From: Nicola and Stephen Harlow, 25 Upper Drive, East Preston

Planning Application EP/7/21 HH

Objection and comments relating to proposed new windows

Drawing No Status Revision
203075/ 010

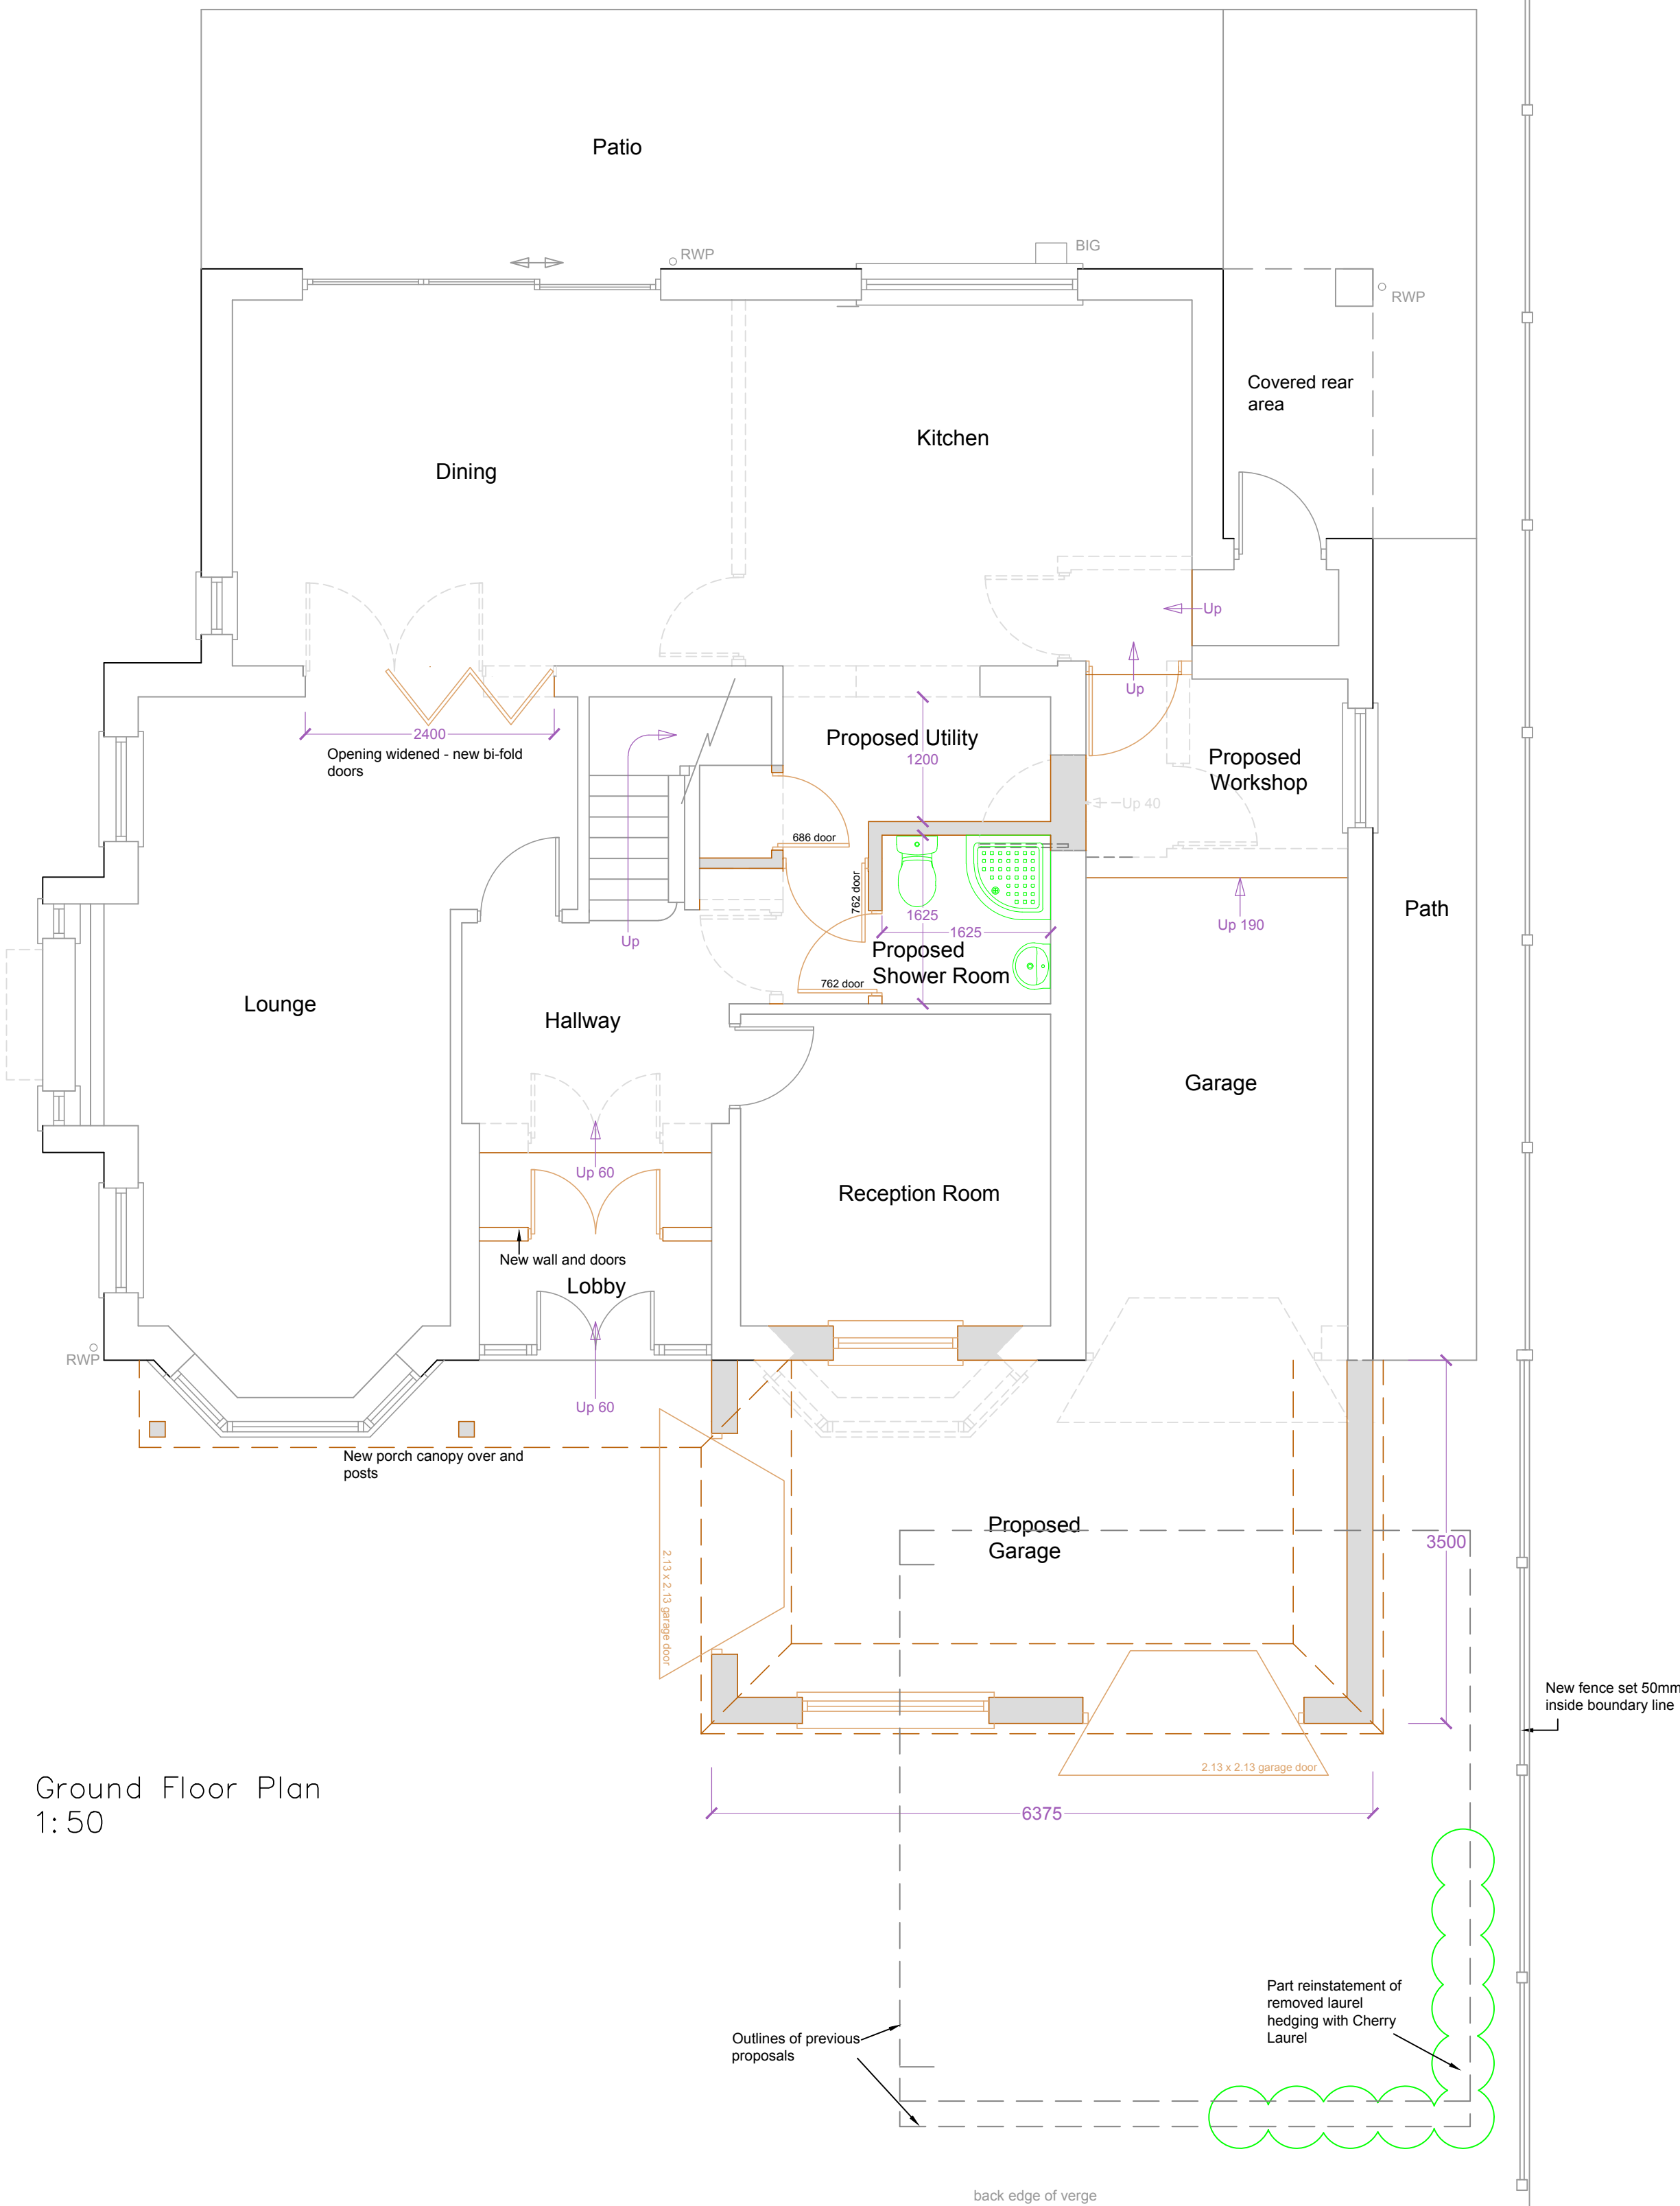
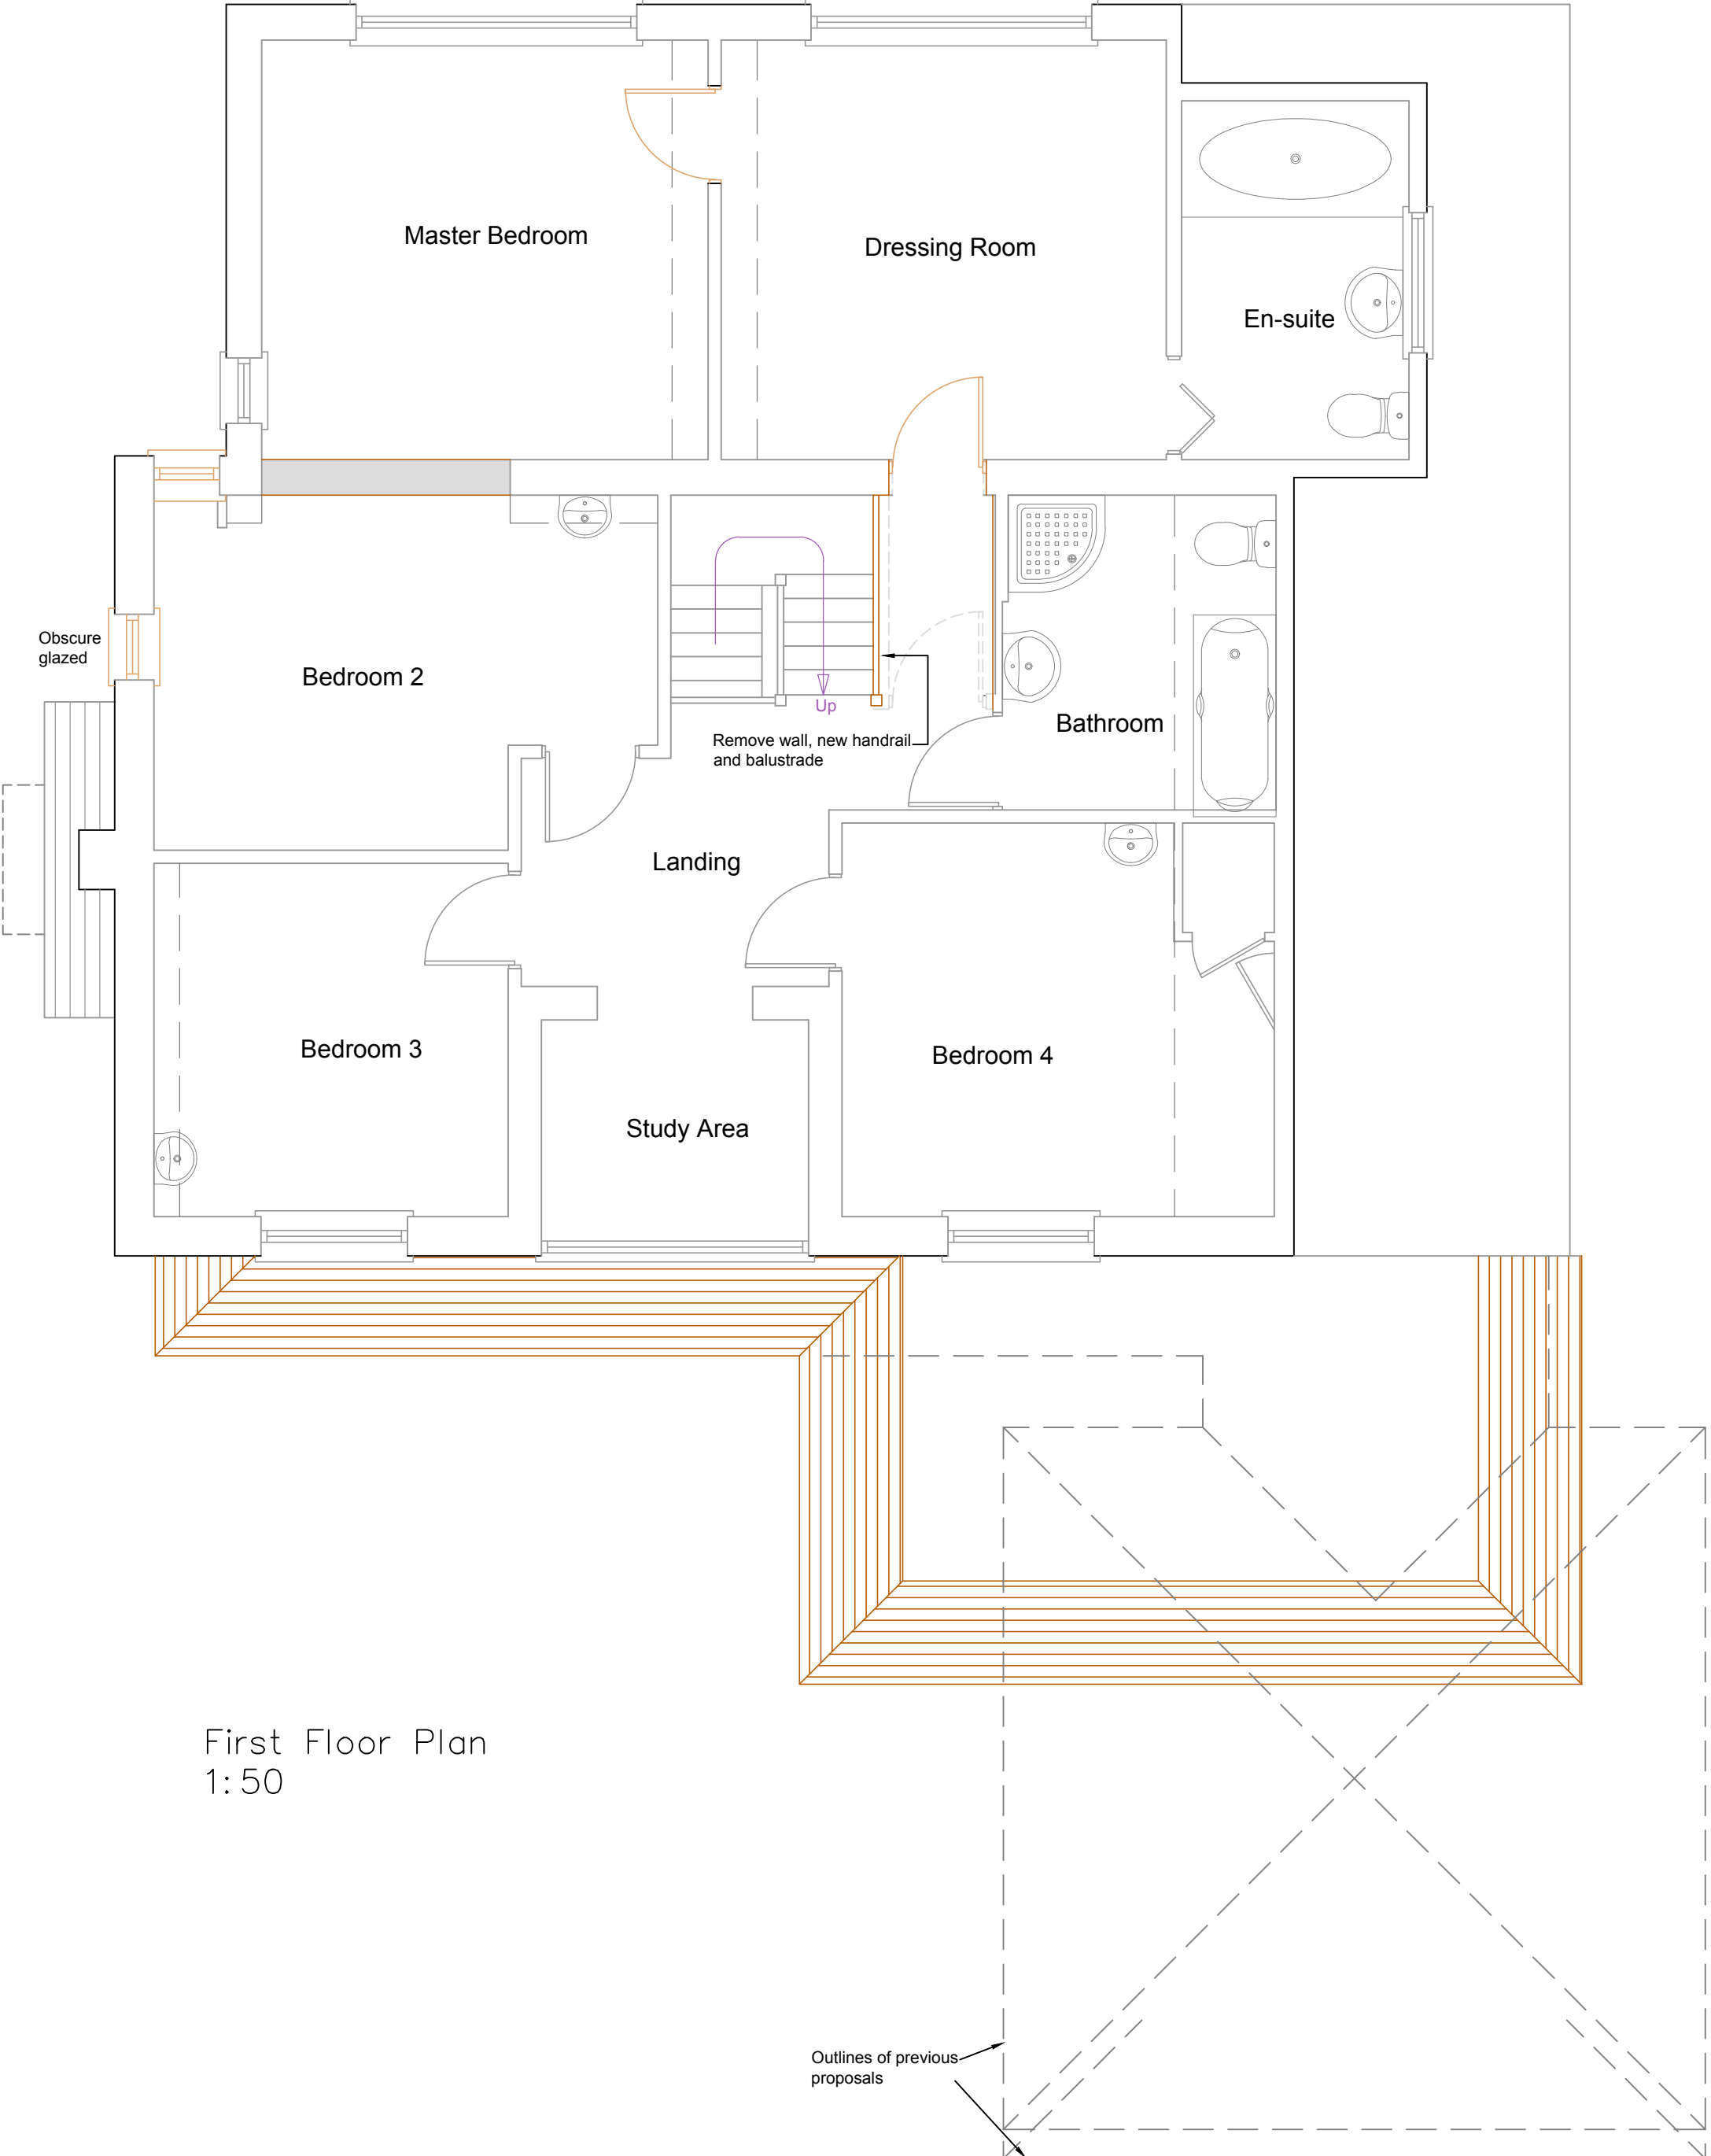
4. The problem of the potential loss of privacy has been created by the applicant. Trees and shrubs have been removed and the applicant wants to change the internal layout of the 23 Upper Drive. The proposed windows are not needed if the applicants planned alterations to the 1st floor living space are not carried out. If the current floor plan as shown in drawing 203075/08 is not changed there is no need for additional windows.

Drawing No Status Revision
203075/ 011

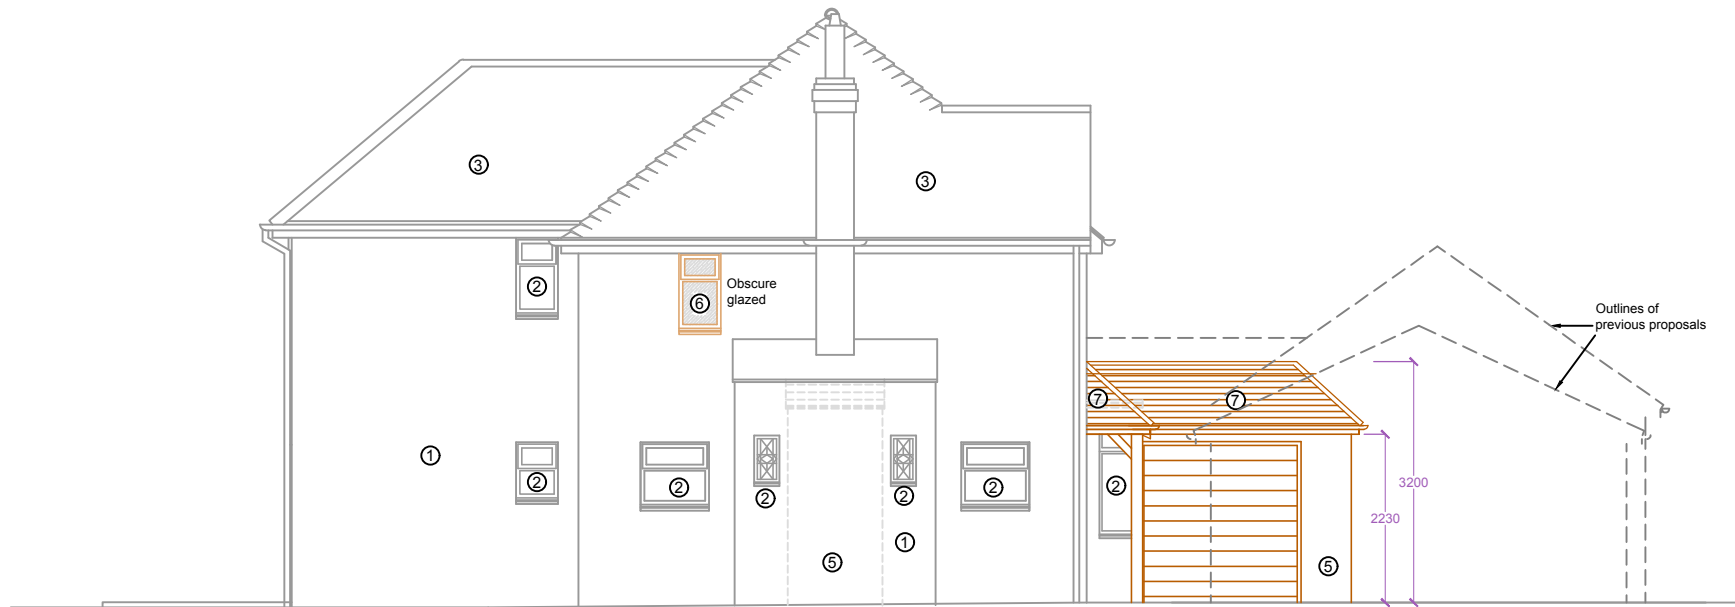
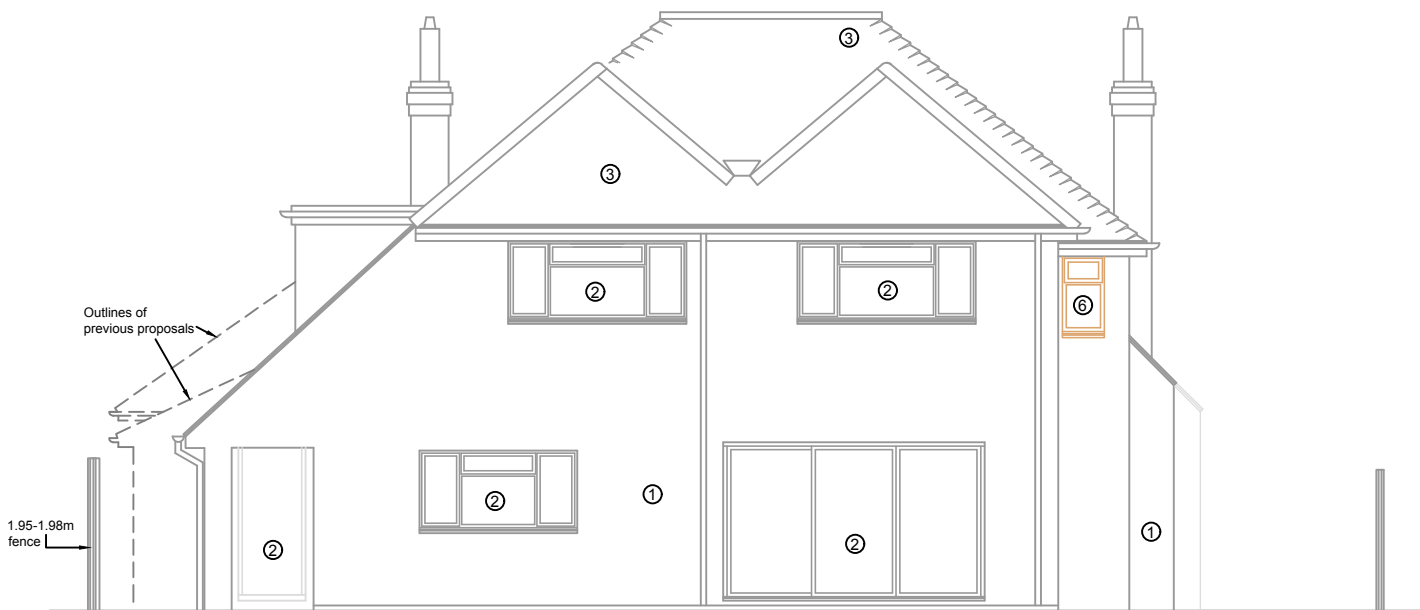
The description of proposed works in planning application EP/7/21/HH does not refer to new windows. However, the plans show proposals to install 2 new windows, both on the (south) side elevation but one angled so it is only visible on the plan showing the west elevation.

The proposed most easterly window will lead to overlooking of the garden and a bedroom of 21 Upper Drive and the garden and living space of 59 Manor Road.

The proposed most westerly window will lead to overlooking of the garden and living space of 59 Manor Road from a different angle. As a result the applicant will have a view of the whole of the back garden and living space of 59 Manor Road.

Plan drawing 203075/011 shows obscure glass for the proposed most easterly window but obscure glass doesn't stop overlooking, it just means the image is distorted or blurry. Also, the glass can be changed at any time by the current or future occupants.

The proposed windows will lead to overlooking of neighbouring properties, in particular 21 Upper Drive and 59 Manor Road.

The plans for 23 Upper Drive do not include any additional design measures or landscape screening (in fact the landscape screening has been removed). In order for the proposed windows to be in accordance with The Design Guide other initiatives would be required.
